Comments for Planning Application 21/02839/PLF

Application Number: 21/02839/PLF

Address: Manor Farm Low Field Lane Haisthorpe East Riding Of Yorkshire YO25 4NX

Proposal: Erection of a lean-to extension to be used for agricultural machinery storage and repair

Figure 20 Map of the site and immediate surrounds, showing impermeable surfaces and outline drainage system

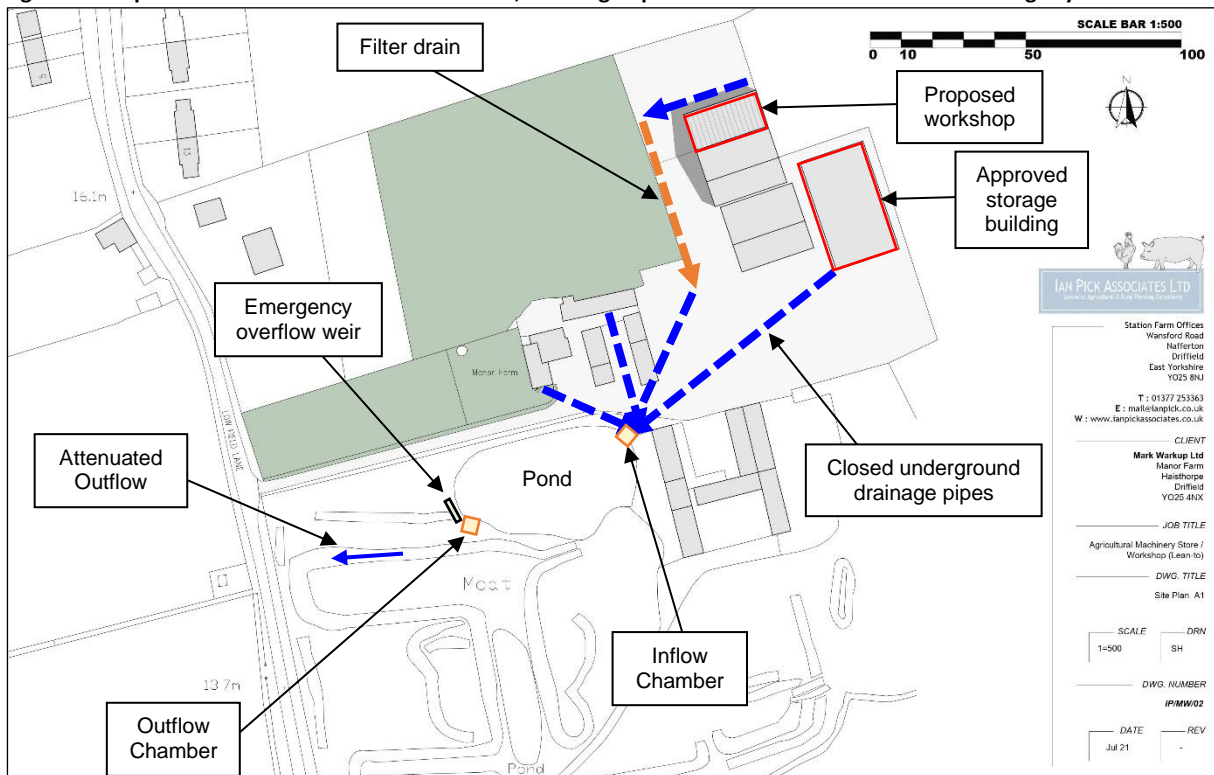
The storage unit already built (and subject to the condition of satisfactory drainage installed prior to the building being brought into use) was built on additional land outside that of the boundary of the existing site. The land was part of an adjacent field, rain water falling on this land would previously flow naturally down the sloping land to the drainage ditch at the end of the same field and did not enter the current commercial premises .The Unit is in operation and would appear from the Risk assessment that underground drainage is already installed (clearly altering the natural flow of the water) Figure 18 is in fact not an image of the last shed built but an older one. There are no images to suggest the drainage shown in fig 20 is in operation/built.
